REPORT N° 70013258-RSA

LAND AT WESTERGATE

STAGE 1 ROAD SAFETY AUDIT DESIGNERS
RESPONSE

PROPOSED S278 SIGNALISED JUNCTION

© WSP Group Ltd

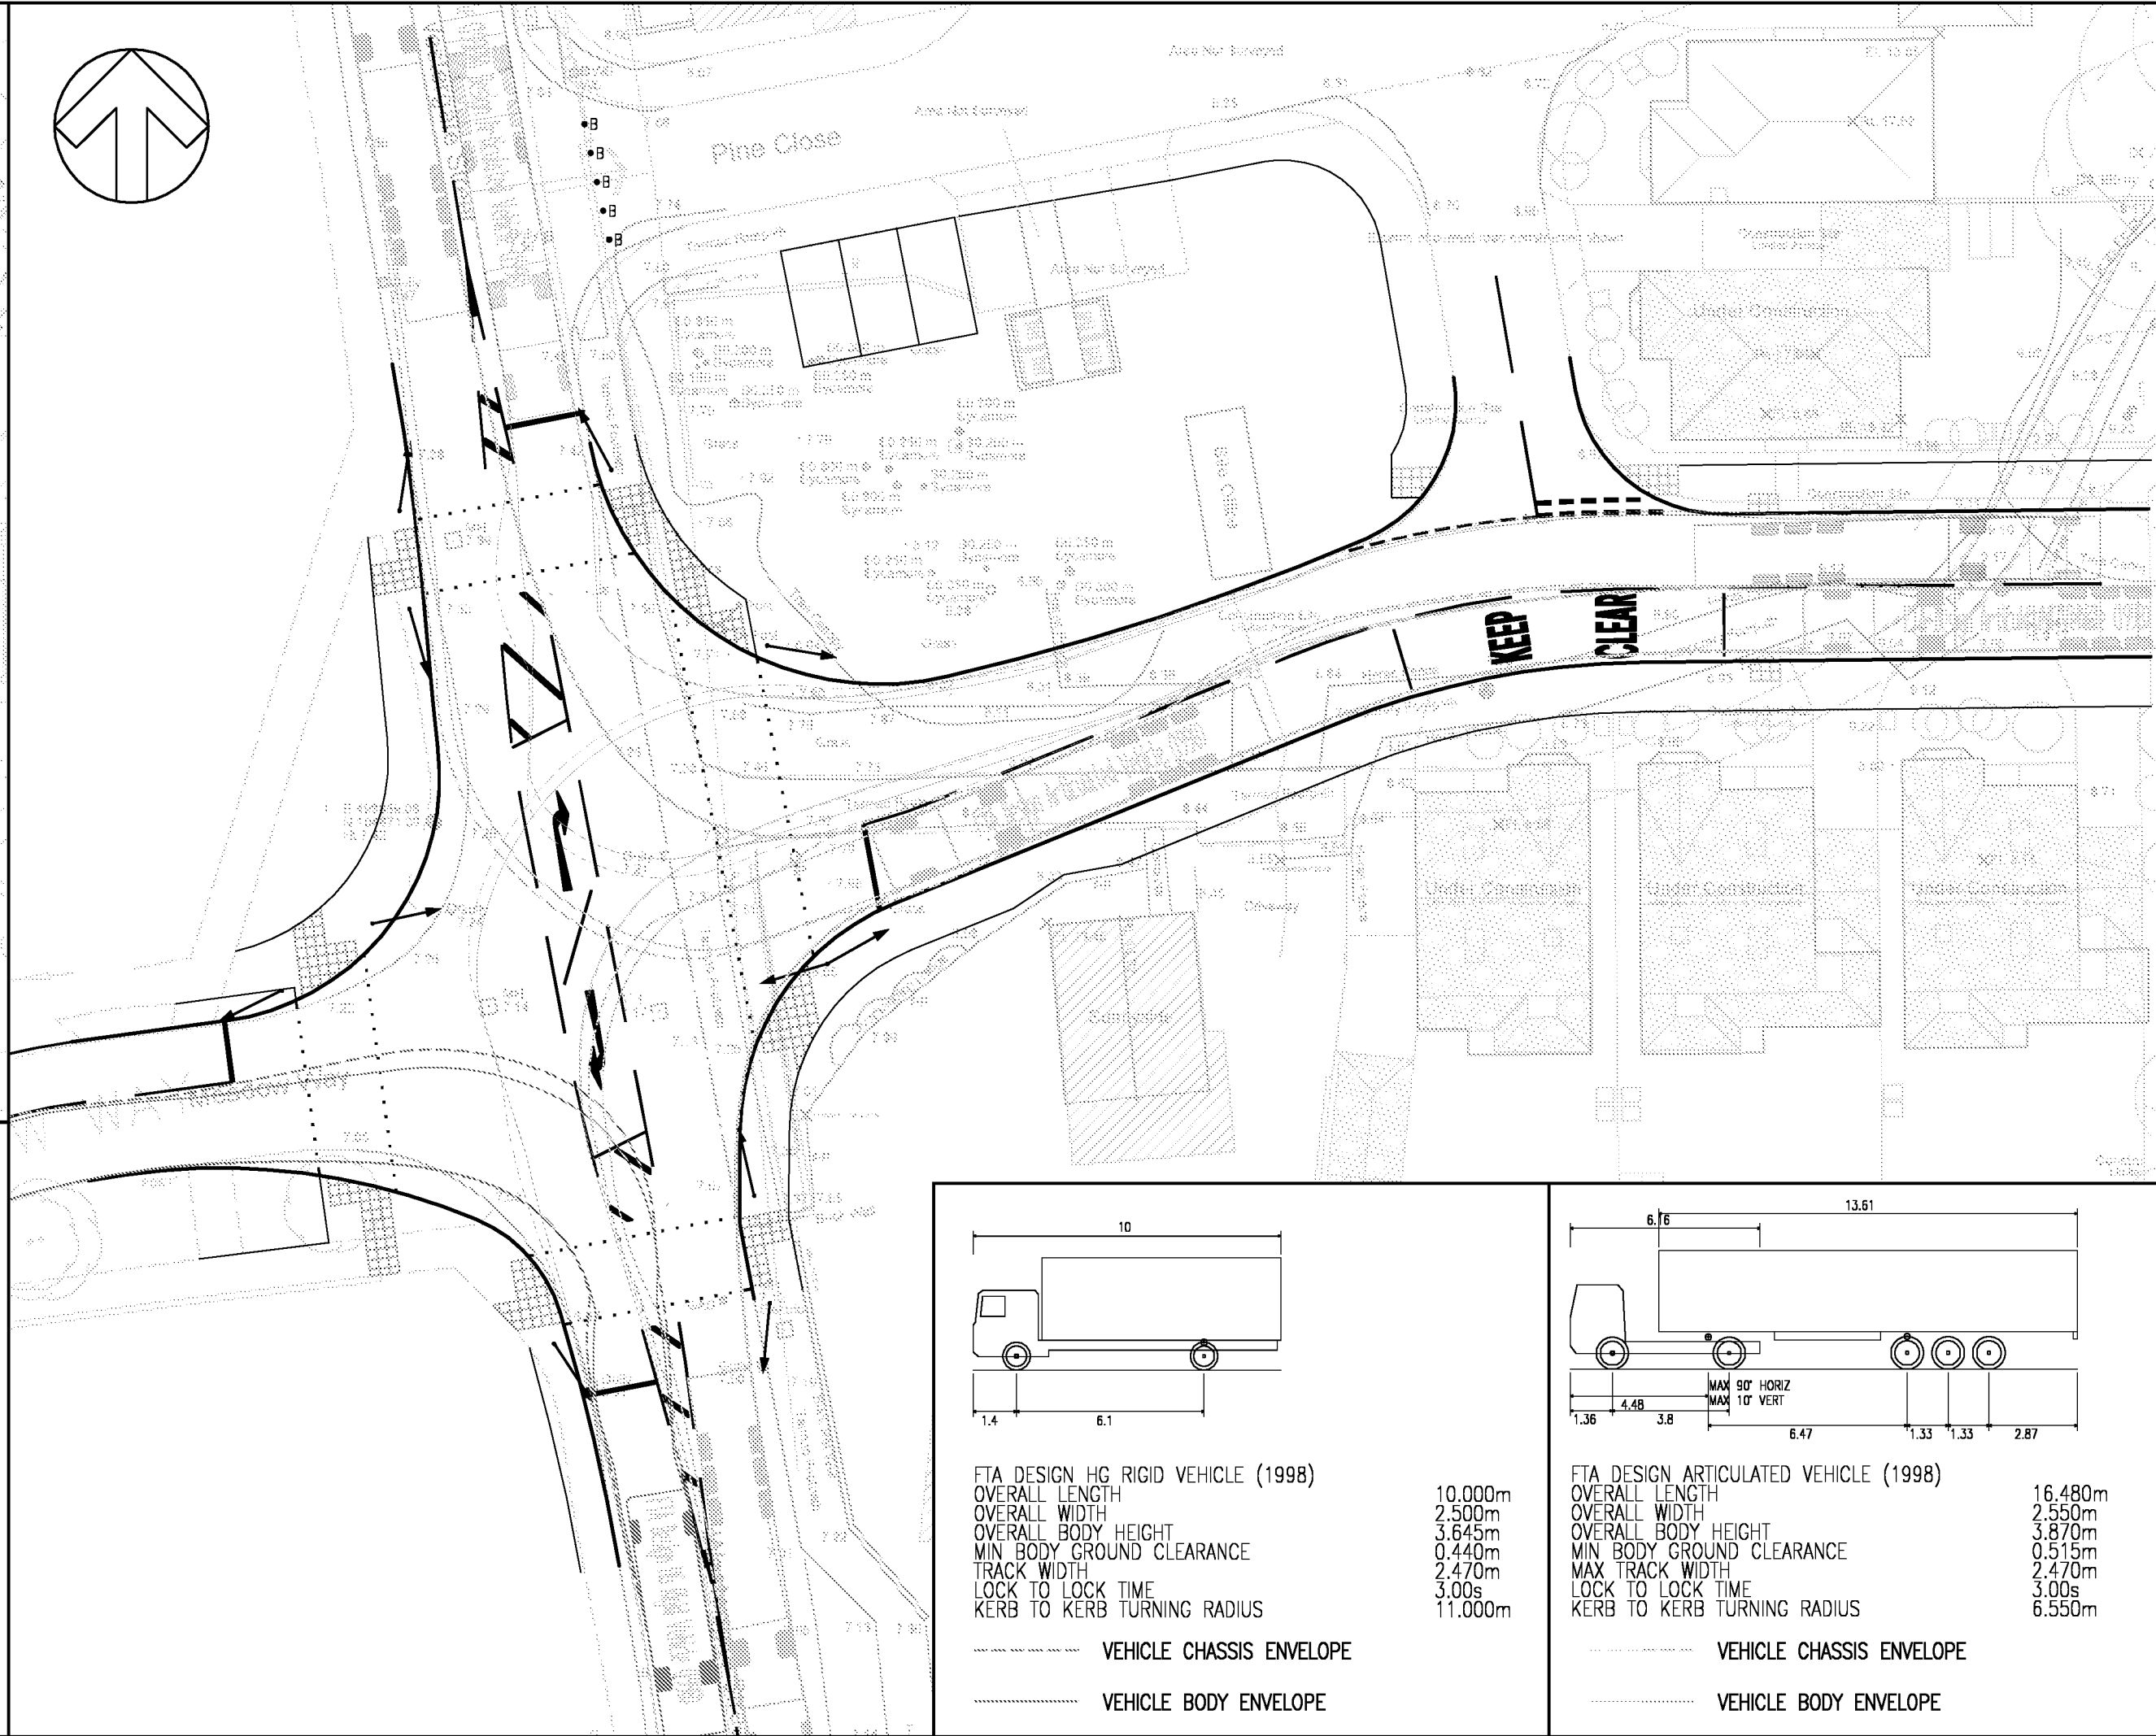
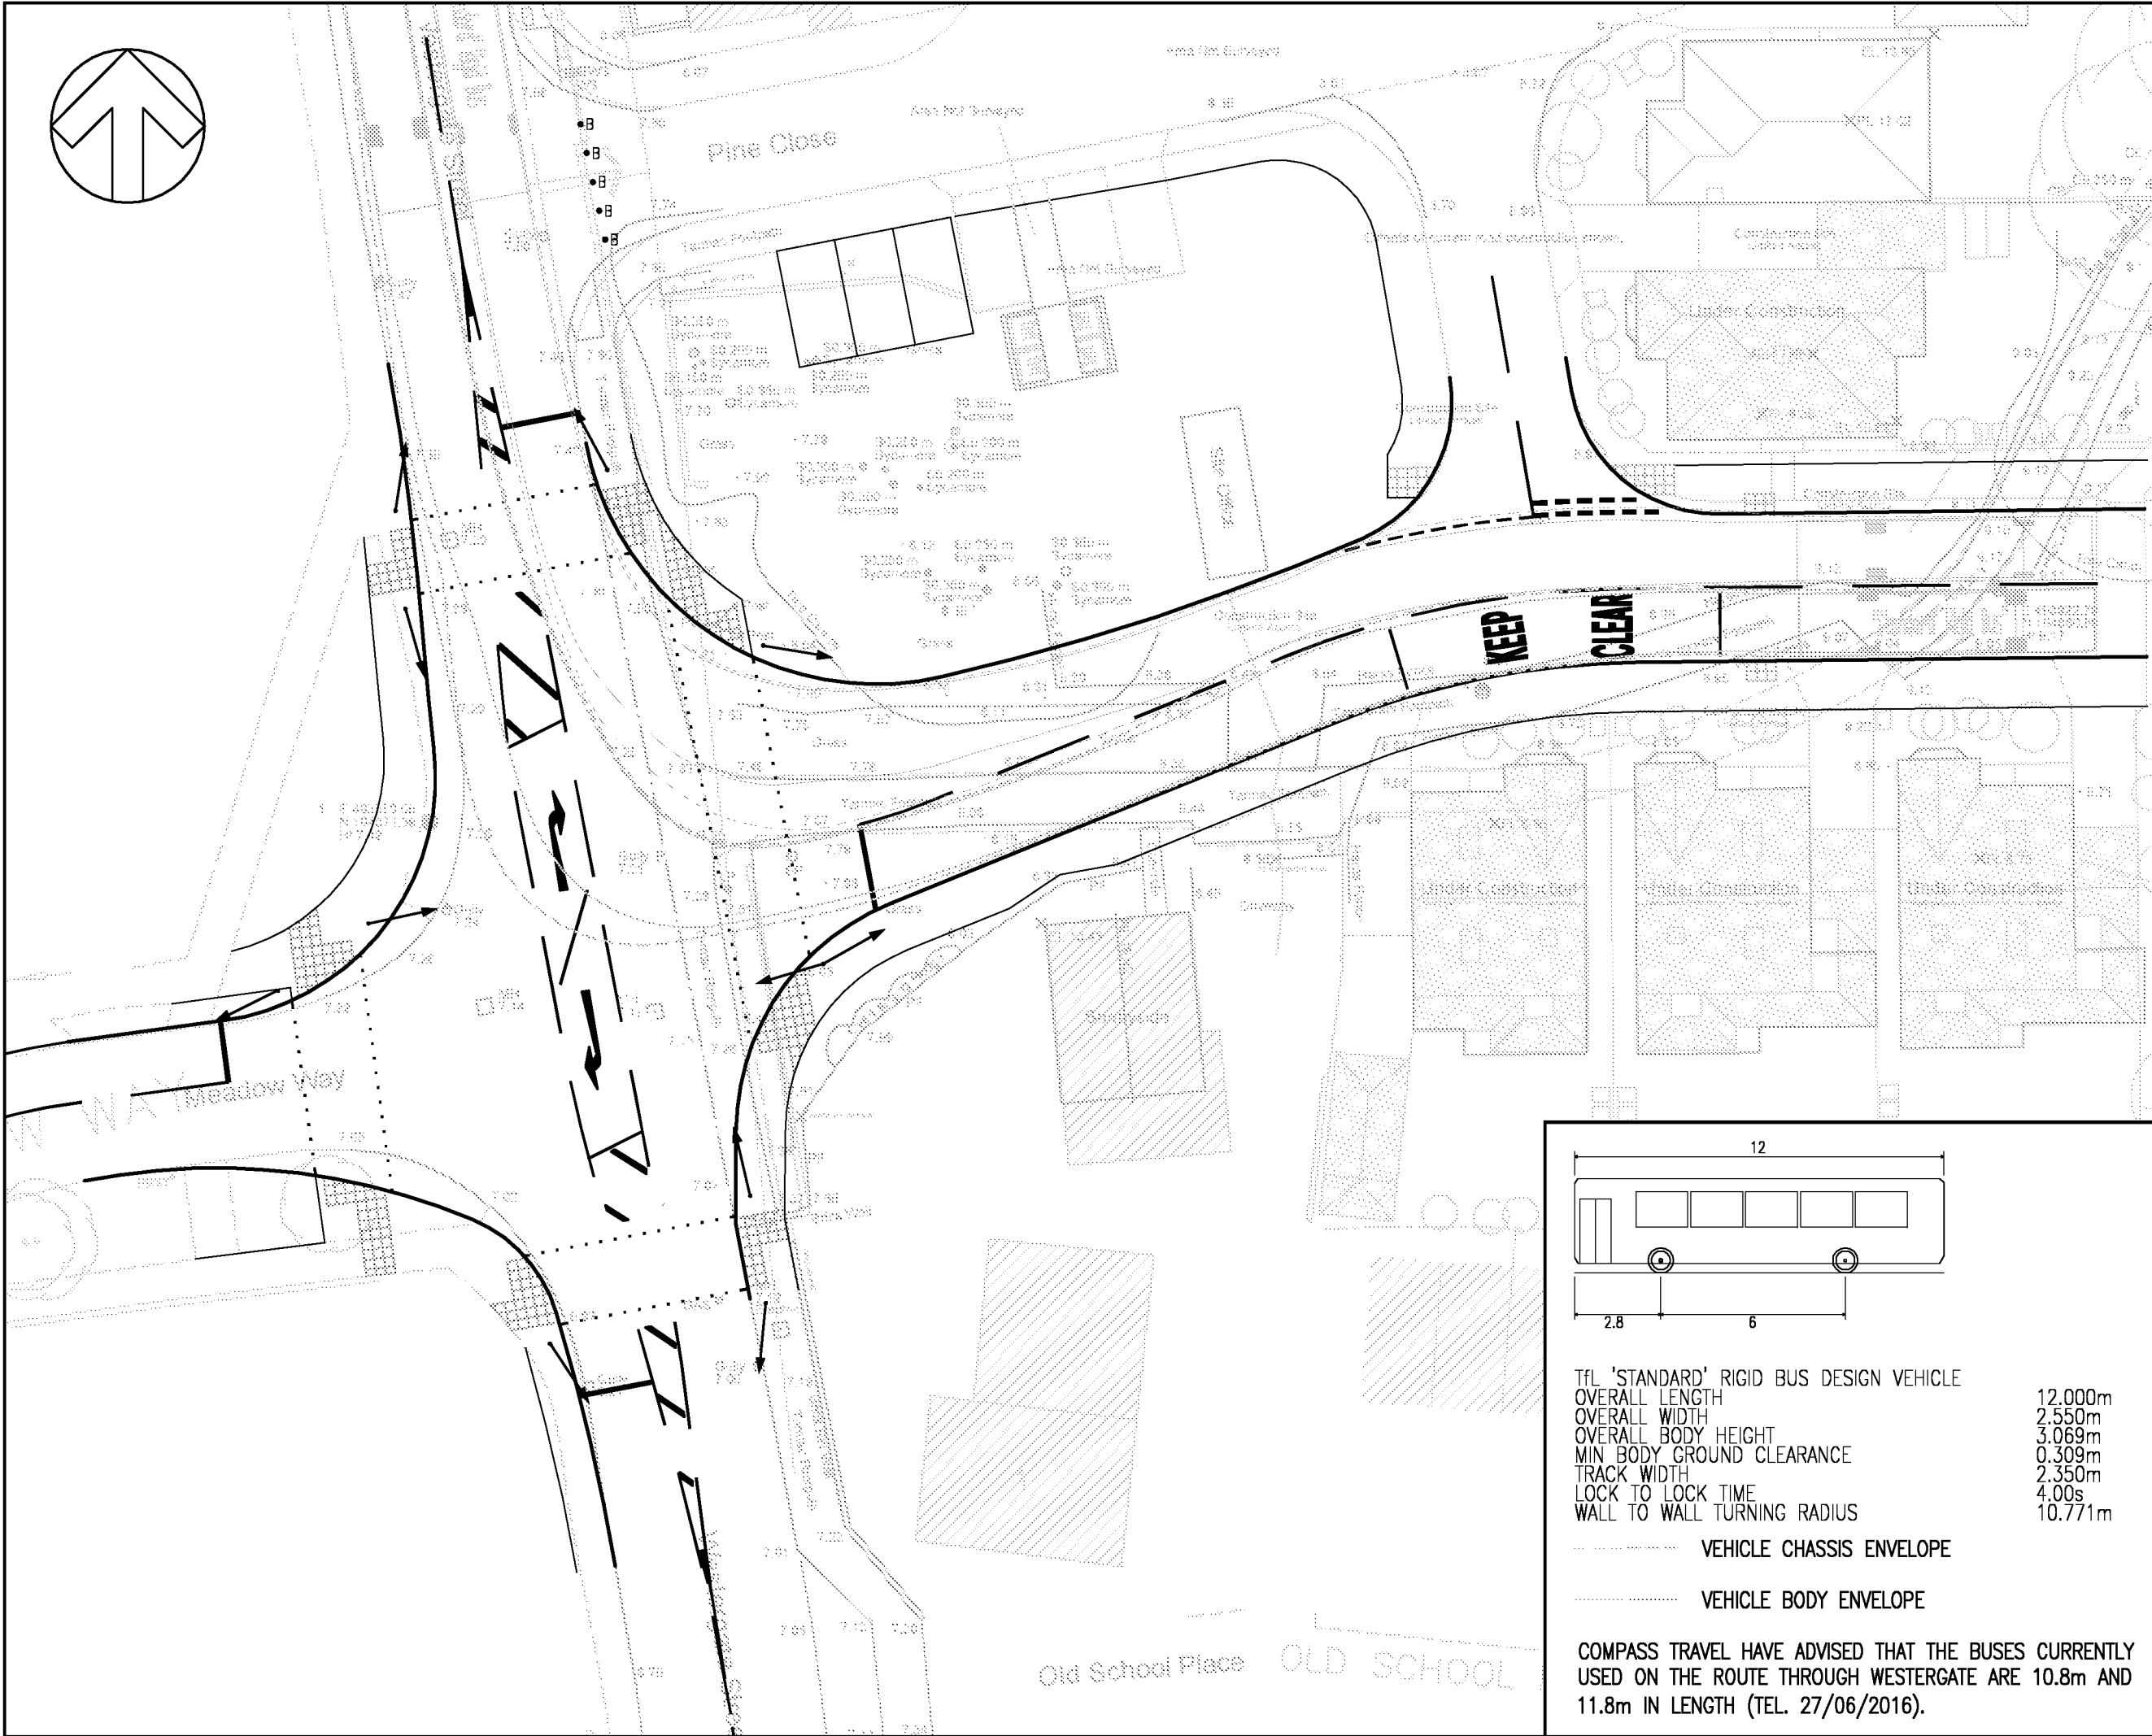
3.3.1 **PROBLEM** *(Drawing ref: 3258/GA/004 Rev C & /ATR/003 Rev B)*

Location: (A) A29 Westergate Street, south of the junction with Meadow Way and the new access road.

Summary: Risk of inadequate forward visibility of stop line, waiting vehicle(s) and/or waiting pedestrians.

The proposed forward visibility distances indicated on the Design Drawings are shown as below Standard and will require a Departure to be sought. Whereas the current proposals for northbound drivers forward visibility of the offside primary signal head is shown as 59m and notation included that it accords with MfS SSD for a speed of 37mph, (which during the site inspection was generally observed as such passing speeds), the nearside primary signal head is shown to only be 37m. Whilst it appears that since the earlier Stage 1 some changes to the northbound stop line position may have been carried out, northbound drivers forward visibility of a vehicle waiting at the stop line or of any pedestrians waiting at the west side to cross the A29 carriageway or in the process stepping off the footway, may still be hidden from clear view. It also appears likely that the offside signal head may at times be hidden from view by passing southbound buses and other high sided vehicles.

It is also understood from the Designer that “the junction would serve approximately 350 dwellings and operate within capacity when assessed up to 2017. Queuing on the A29 reached 18 vehicles in the Northbound direction and 14 vehicles in the southbound direction in the AM peak and 11 vehicles in the Northbound direction and 21 vehicles in the Southbound direction in the PM peak”. Consequently, concern arises that risk of northbound tail-end shunt conflicts at this junction may be higher than other signalised junctions, especially when large numbers of vehicles previously queuing at the level crossing are released when gates are opened and also congestion may result, or danger arise if northbound vehicles unexpectedly swerve into the bellmouth of Meadow Way when passing stationary right turning traffic, as indicated on the Swept Path Analysis Drawing.

The proposed junction design may need to be revisited with a view to investigating scope for shifting the northbound stop line and corresponding signal poles a few more metres further southwards of the currently shown position, which may also provide safer scope for large vehicles turning sharp left manoeuvre from the new site access road. A high level off-side secondary signal head may also need to be included.

The yellow box markings indicated for the southbound traffic flow may also need to be extended to also include the northbound through flows.

It is further recommended that high friction surfacing should also be incorporated on the northbound approach for sufficient length to mitigate the potential northbound vehicle queuing and risk of failure to perceive the red lights associated with the signalised junction and pedestrian crossing facility.

REF.	COMMENT	DESIGNERS RESPONSE
3.3.1	Location: (A) A29 Westergate Street, south of the junction with Meadow Way and the new access road. Summary: Risk of inadequate forward visibility of stop-line for waiting vehicles and/ or waiting pedestrians. Recommendation: The proposed junction design may need to be revisited with a view to investigating scope for shifting the northbound stop line and corresponding signal poles a few more metres furthers southwards of the currently shown position which may also provide safer scope for large vehicles turning sharp left manoeuvre from the new site access road. A high level off-side secondary signal head may also need to be included. The yellow box markings indicated for the southbound traffic flow may also need to be extended to also include the northbound through flows. It is further recommended that high friction surfacing should also be incorporated on the northbound approach for sufficient length to mitigate the potential northbound vehicle queuing and risk of failure to perceive the red lights associated with the signalised junction and pedestrian crossing facility.	<i>It has not been possible to relocate the A29 northbound stop-line further southwards due to the need to maintain junction inter-visibility between stop-lines. While full inter-visibility as measured in DMRB is not possible the current arrangement allows visibility between the A29 northbound and site access stop-line, which includes the extent of access road pedestrian crossing. Moving the A29 northbound stop-line further south would remove visibility between stop-lines.</i> <i>The ability to relocate the northbound stop-line further south is also limited by the residential property located on the south eastern corner of the junction, whereby such a modification would obstruct the visibility between the A29 northbound and site access road stop-line.</i> <i>The option of relocating the access road stop-line slightly westwards (to extend the limits of the junction inter-visibility further southwards on the A29 northbound) has been explored but this is not possible due to proximity of the pedestrian crossing on the access road to the A29 southbound lane.</i> <i>High friction surfacing will be incorporated into detailed design stages of the proposed junction.</i>
